# Comments for Planning Application 20/01514/FUL

Application Number: 20/01514/FUL

Address: Wilmington Hall Farm Broad Lane Wilmington Kent DA2 7AG

Proposal: Use of the site as a Construction Yard to store specialist foundation products together with installation of new modular office building, car parking provision and new sliding gate to existing entrance

00 Block Plan

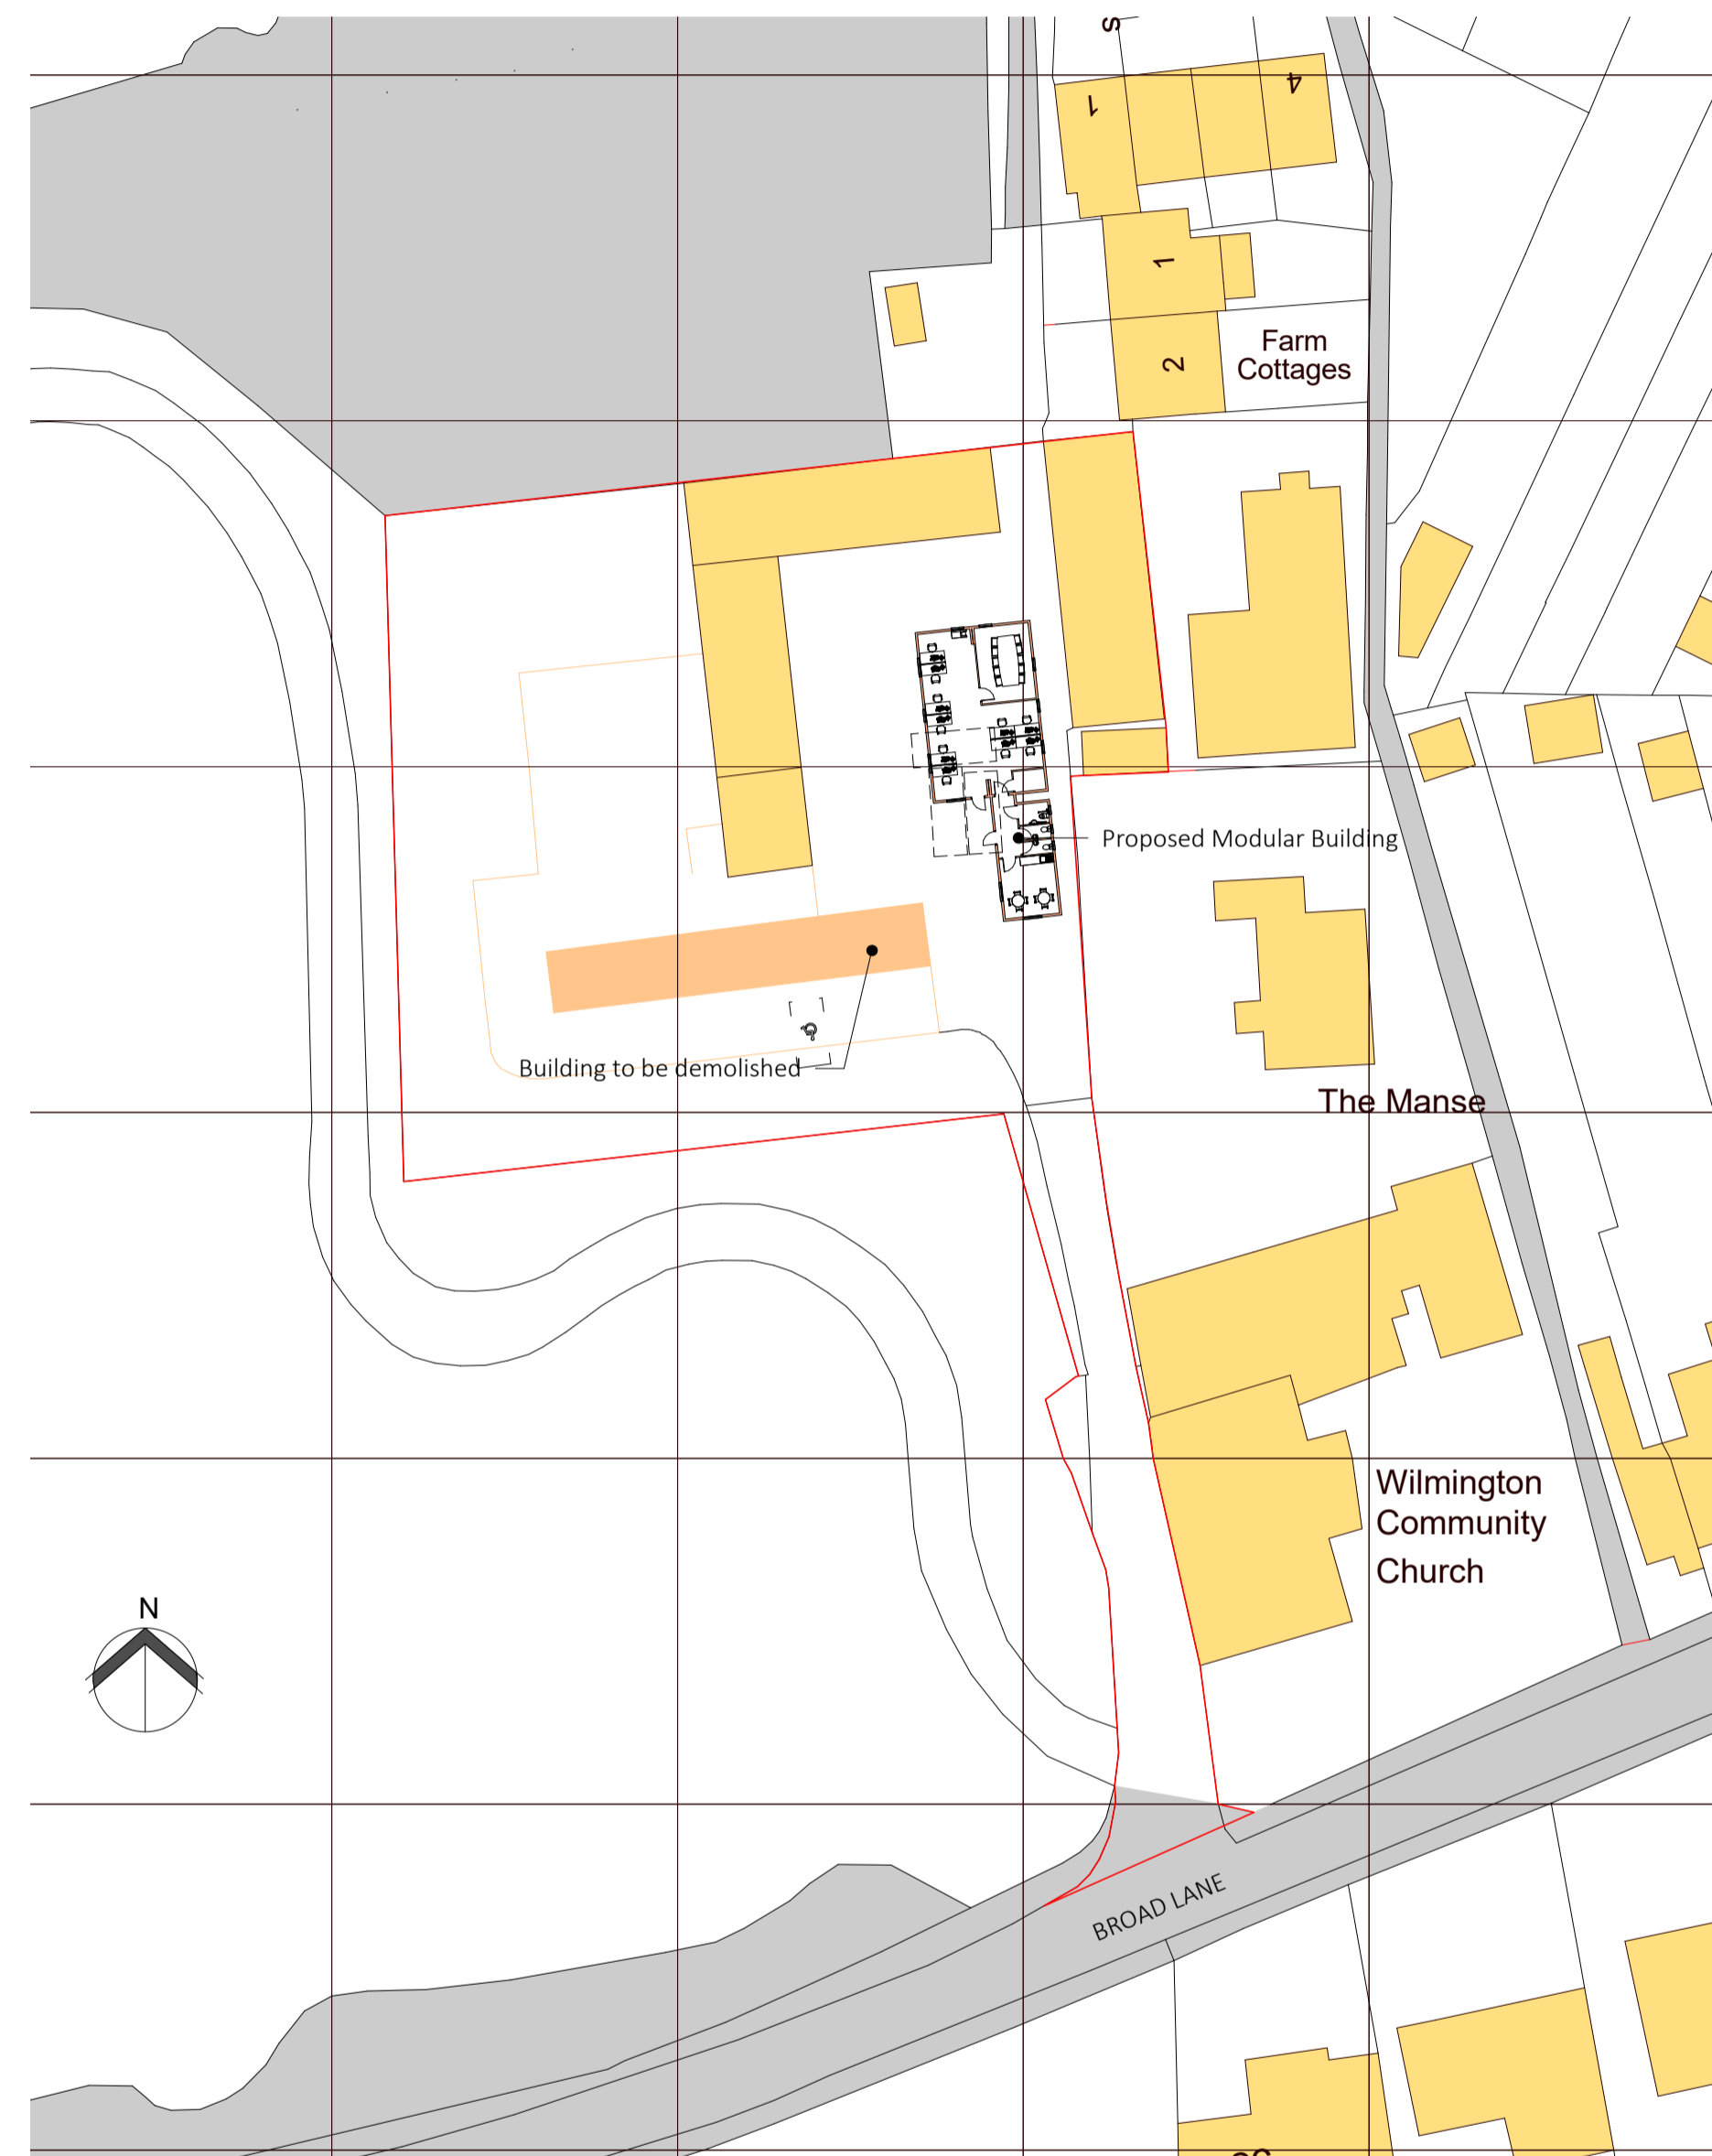
The planning application states that the site will only be used for parking cars. In the application there will be parking for 10 cars only and does not mention parking of a HIAB vehicle, referred to in their and shown on the site plan. There is a letter from Ian Alcorn of Roger Bullivant Ltd stating that they intend to park one vehicle in the yard. The vehicle is described in the Design and Access statement as a 11m long vehicle. There is space for more than one 11m vehicle on the premises, which may occur in due course.
